From: Brenda Larsen [brenda.larsen@co.kittitas.wa.us]
Sent: Tuesday, October 27, 2009 12:10 PM
To: Katie F. Cote
Subject: RE: Fire Condition on Plat
Attachments: Tamarack Starlight Heights and Meadow Springs.doc

Re: Tamarack Ridge (LP-07-00018), Starlight Heights (LP-07-00016) and Meadow Springs Plats
(LP-07-00015)

TO: Anna Nelson, CDS
FROM: Christina Wollman, Planner II
DATE: October 27, 2009
SUBJECT: SEPA Mitigation: Meadow Springs P-07-15, Starlite Heights P-07-16, Tamarack Ridge P-07-18

SUBJECT: Starlite Heights Cluster Plat LP-07-00016

SITE PLAN
OF
STARLITE HEIGHTS
A PORTION OF SECTION 01, TOWNSHIP 19 N., RANGE 14 E., W.M.
KITTITAS COUNTY, WASHINGTON

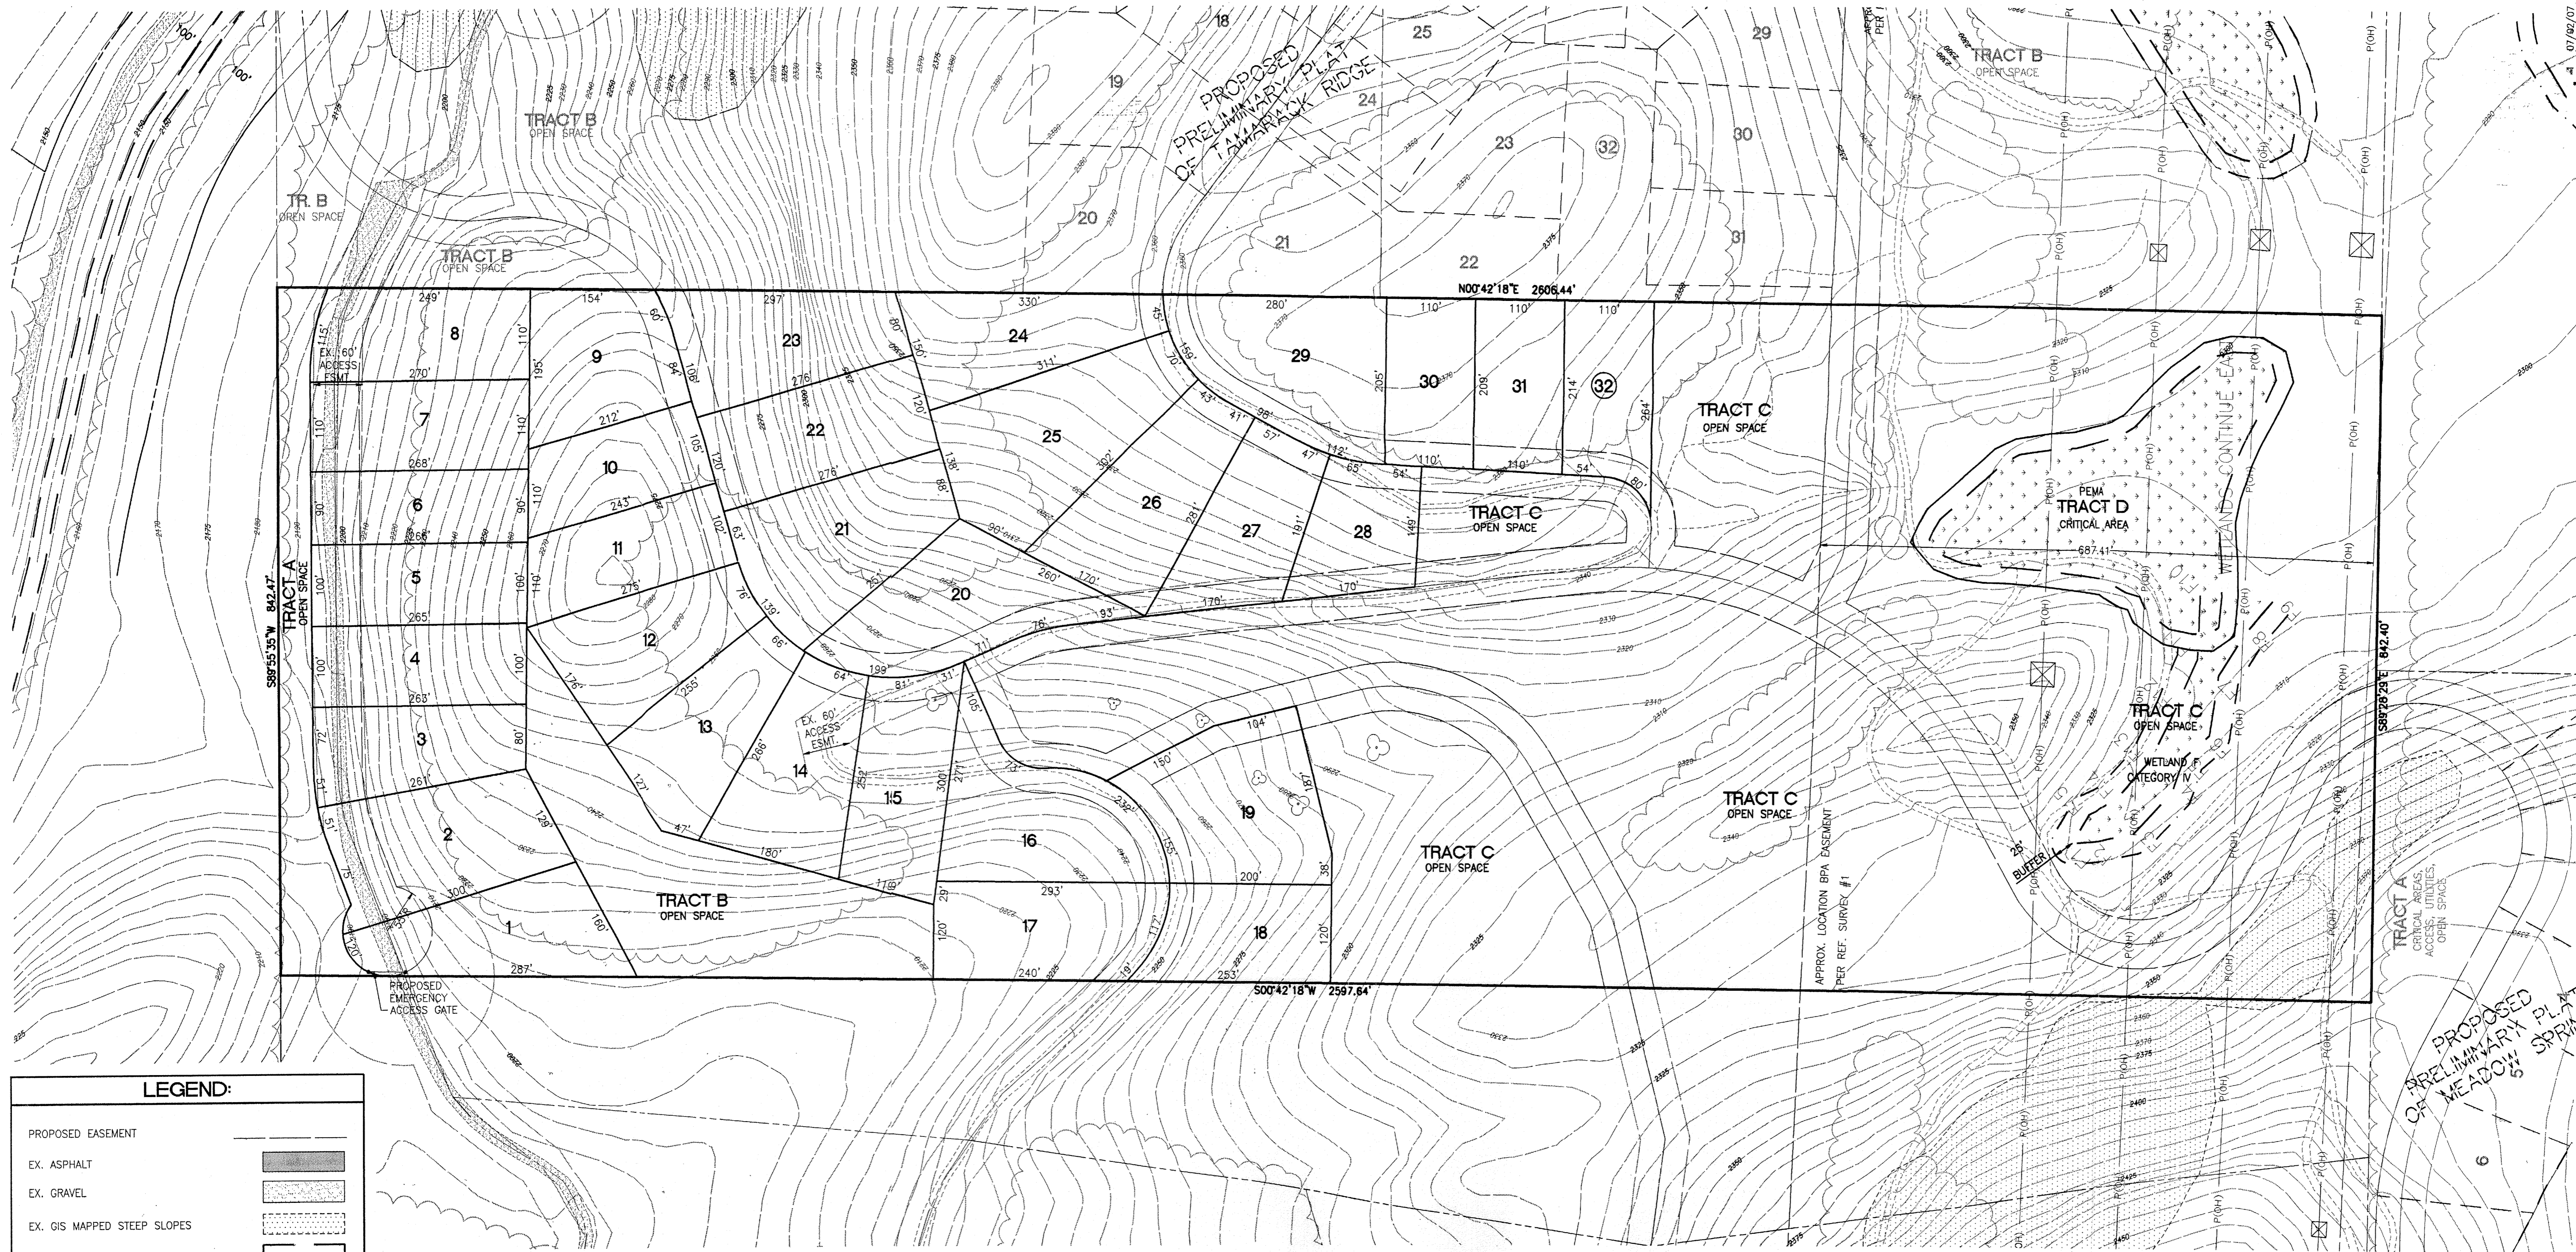
6. Easements: It appears Lots 22 and 23 will be accessed by an easement crossing Lot 24. All easements shall be clearly labeled with the easement width and description.
7. Private Road Improvements: The main access road leading from Westside Road to Danko Road shall be constructed as a High-Density Private Road that serves more than 40 lots. Access easements shall be a minimum of 60' wide. The roadway shall be constructed to AASHTO standards, have a maximum grade of 12%, and be designed by an engineer. Design plans shall be approved by the County Engineer prior to construction. See current Kittitas County Road Standards, 9/6/05 edition.

8. Cul-de-Sac: A cul-de-sac turn-around having an outside right-of-way or easement diameter of at least 110 feet shall be constructed at the closed end of all dead-end roads serving 3 or more lots. The driving surface shall be at least 96 feet in diameter. Cul-de-sacs must also conform to the requirements specified by the 2006 International Fire Code. Contact the Fire Marshal regarding any additional cul-de-sac requirements.

9. Bridge: The bridge over the canal shall be constructed to the requirements of KCRS 12.07. The bridge shall have a load rating of at least 75,000 lbs and have a width that will accommodate the lanes and shoulders. The bridge design shall be approved by the County Engineer prior to construction. A licensed engineer familiar with bridges shall certify that the bridge meets these requirements as specified in KCRS 12.07.030 and the bridge certification shall be provided with the road certification.

10. BPA Land Use Agreement: A signed and completed BPA Land Use Agreement is required prior to final approval. Based on BPA's policies, adjustments to the road locations may be required. If the road locations are moved, Public Works shall re-review the new road locations for conformance with Kittitas County Road Standards, and to ensure a 25 mph design speed.
